SAFETY AUDIT RESPONSE SHEET

Project: Hatfield Galleria Revised Road Layout

Stage: 2

Project Number: WIE17416

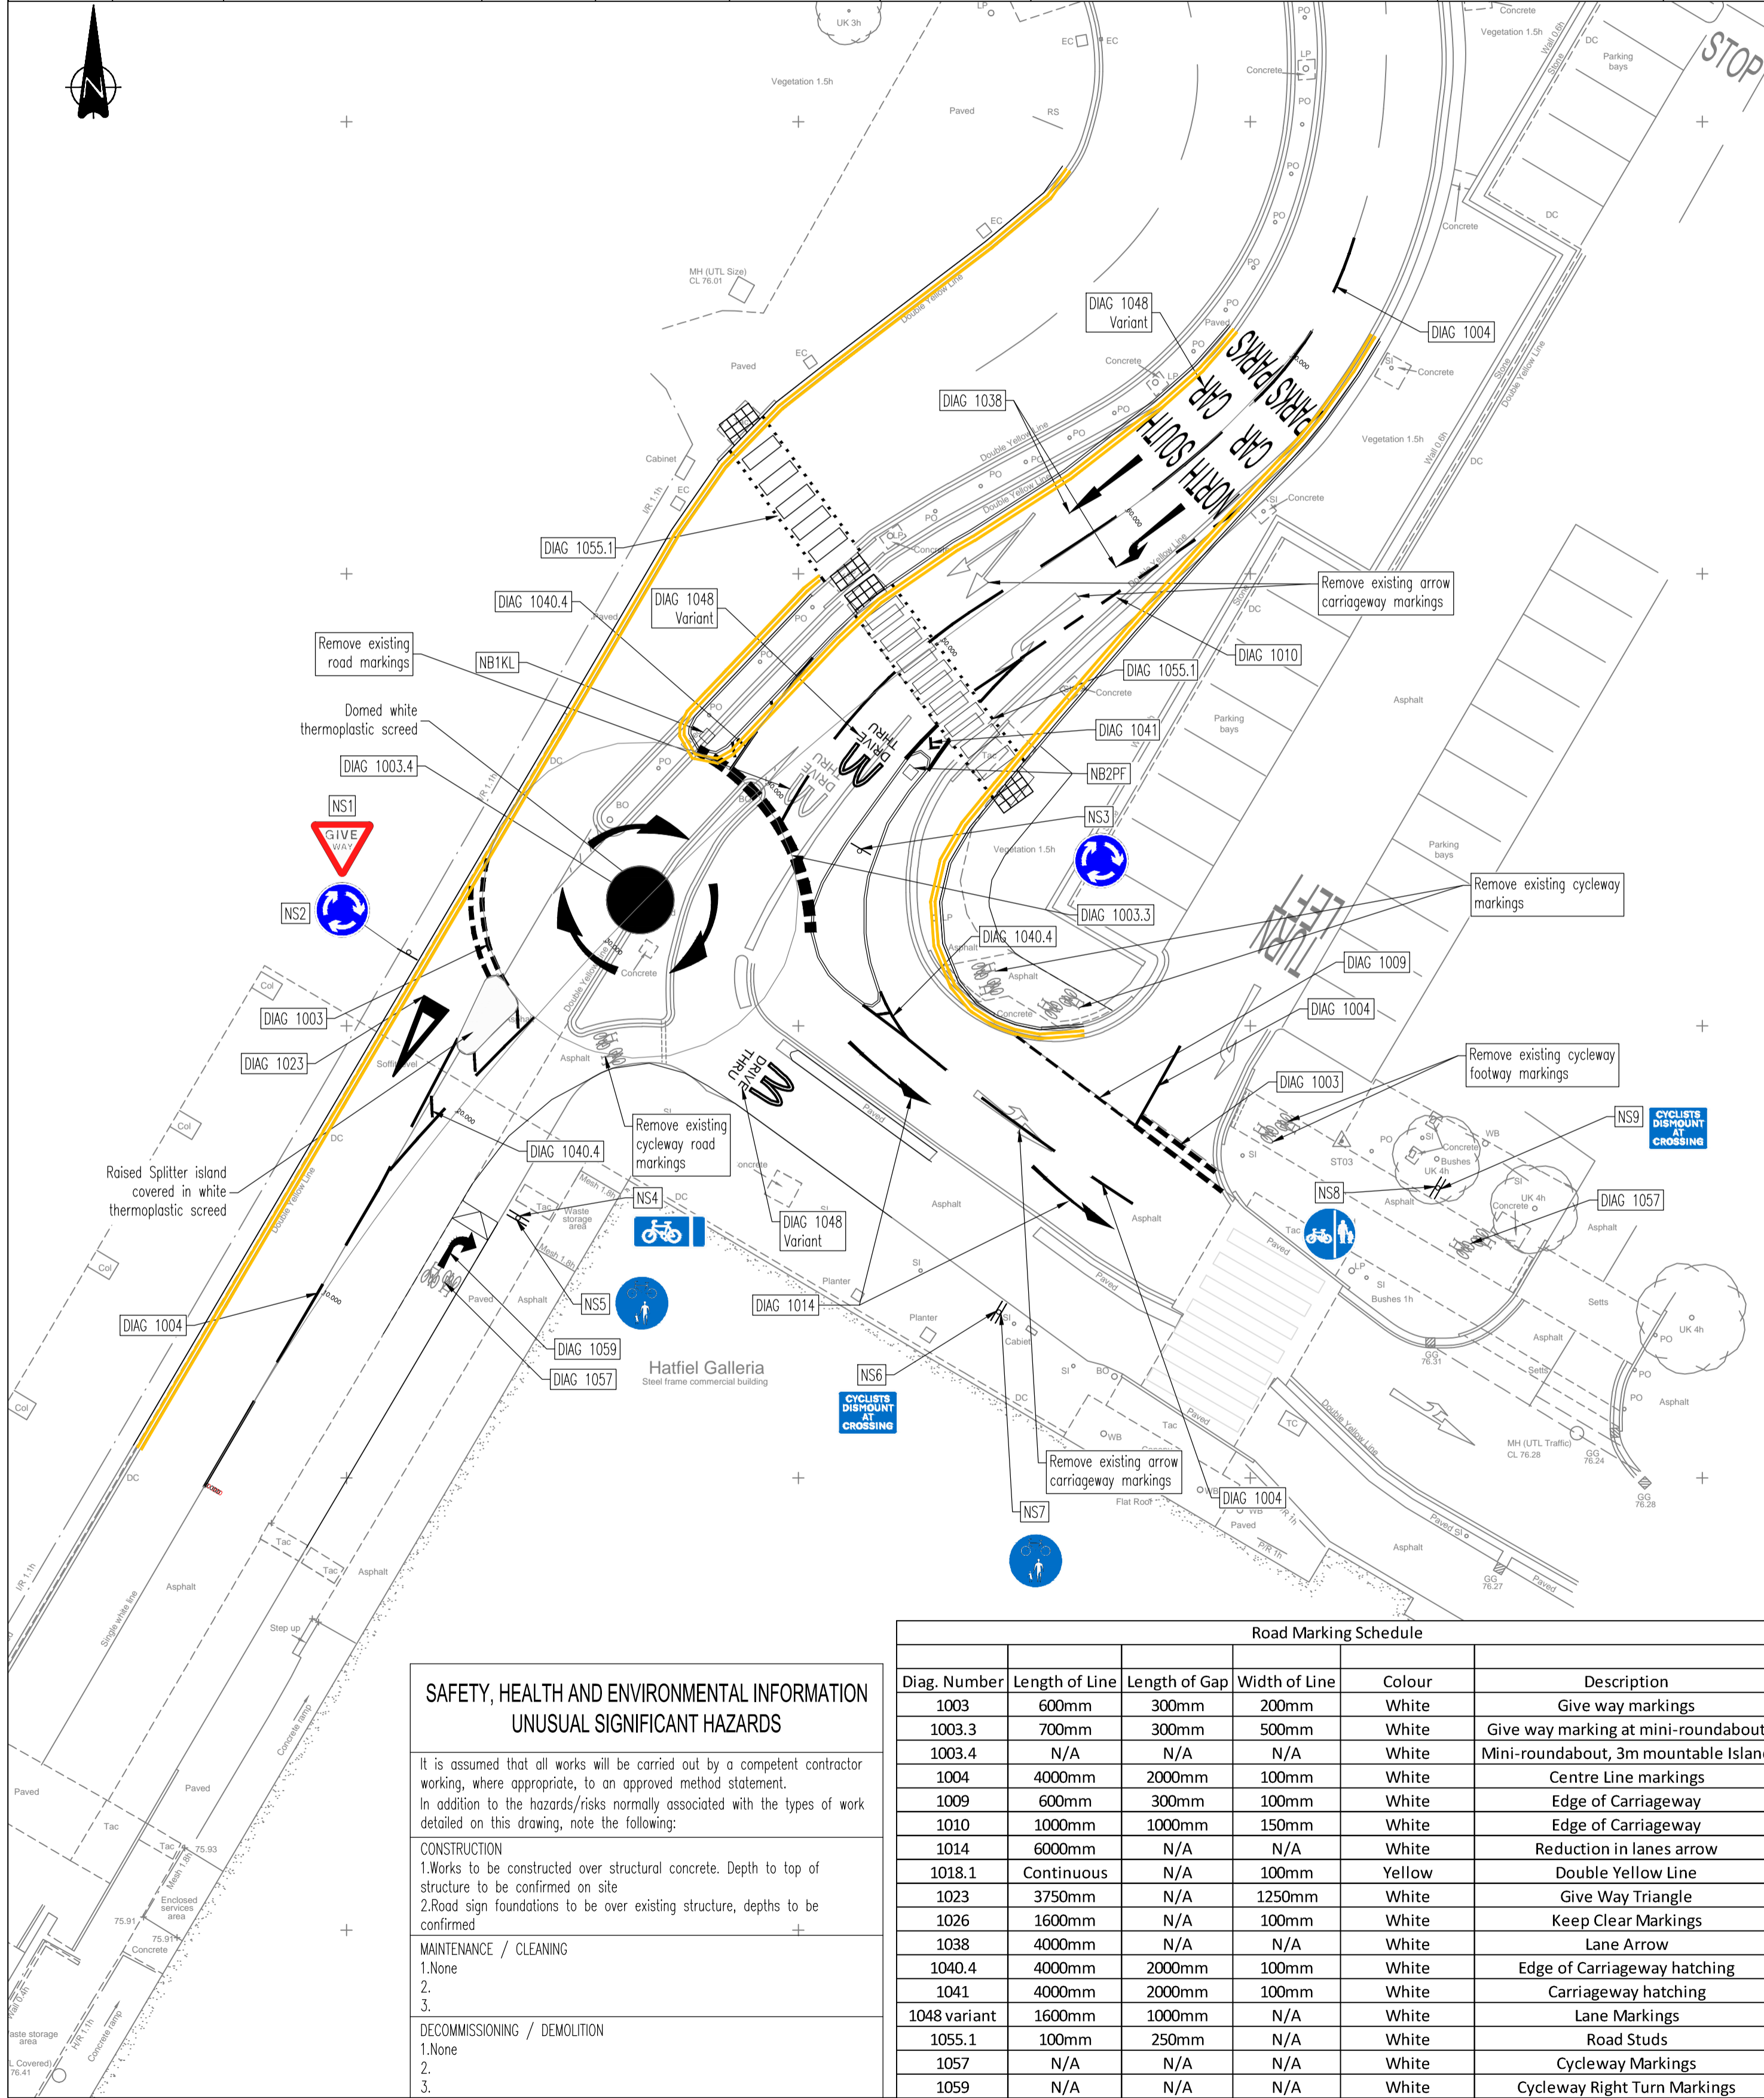
Problem	Agree / Disagree	Reason/Proposals
<p>Problem at Location B Location: Stanley Road – Southern footway by drive through Summary: Risk of pedestrian/cyclist injury The scheme proposes a combined footway cycleway on the existing southern footway alongside the McDonalds drive through. This footway is currently fairly crowded and the width is restricted with planters and street furniture associated with the drive through. Introducing a combined footway/cycleway at this location would leave pedestrians and cyclists vulnerable of collision resulting in injury.</p> <p>In addition to this, a ‘cyclist dismount’ sign is proposed at the eastern end of the southern footway/cycleway and it is unclear where cyclist are meant to continue from this point.</p> <p>Recommendation The Design Team should reconsider the provision of a combined footway/cycleway at this location whilst ensuring there is a continuous route provided for cyclists throughout the scheme.</p>	<p>Agree</p>	<p>A review of footway/cycleway at this location bearing in mind the possibility of cyclists/pedestrians conflict/collisions along the southern footway along McDonalds drive through and crossing point has been undertaken.</p> <p>The intention is that south bound cyclists from the car park side dismount and cross on the existing 4m wide zebra crossing with pedestrians. Once on the Hatfield Galleria side the majority of pedestrians would enter the Galleria, the dismounted cyclists head north-west turning right at the natural pinch-point. As the footway widens to 4m between building and kerb line cyclists mount to join a 22m length of shared cycle/footway on front of Prezzo’s. Although this section has some localised narrowing due to advertisement boards for the McDonald’s drive through the footway widens from 4m to 5m from building to kerb. The entrance to Prezzo is flanked by two planters which will provide a buffer between those already on the shared section and pedestrians exiting Prezzo.</p> <p>In order to make it clearer to cyclist what they are required to do, it is proposed to amend the “cyclist dismount” sign to show “cyclist dismount at crossing”, to add a right turn road marking arrow after the cycle road marking at the eastern end, and add a cycleway symbol east of the crossing point.</p> <p>Drawing no WIE17416/SA/95/0002-A03 has been updated to show the revised cycleway sign plate and addition road markings.</p>

Problem	Agree / Disagree	Reason/Proposals
<p>Problem at Location A Location: Crown Road – Proposed mini roundabout Summary: Risk of injury to vehicle occupants as a result of vehicle conflict</p> <p>The drawing provided showing vehicle tracking of a large car movements at the proposed mini roundabout highlights a southbound vehicle going straight over at the roundabout colliding with a southbound vehicle turning left into the McDonalds drive through lane. This could result in occupant injury of a driver or passenger in either vehicle.</p> <p>Recommendation The design should be revised to safely accommodate all movements at the proposed mini roundabout without vehicles colliding.</p>	Agree	Drawing no WIE17416/SA/06/0001-A03 showing tracking movement of large vehicle has been updated to demonstrate that a southbound vehicle and a turning left vehicle into the McDonalds drive through lane do not collide when both if both vehicles enter the mini roundabout at the same time.
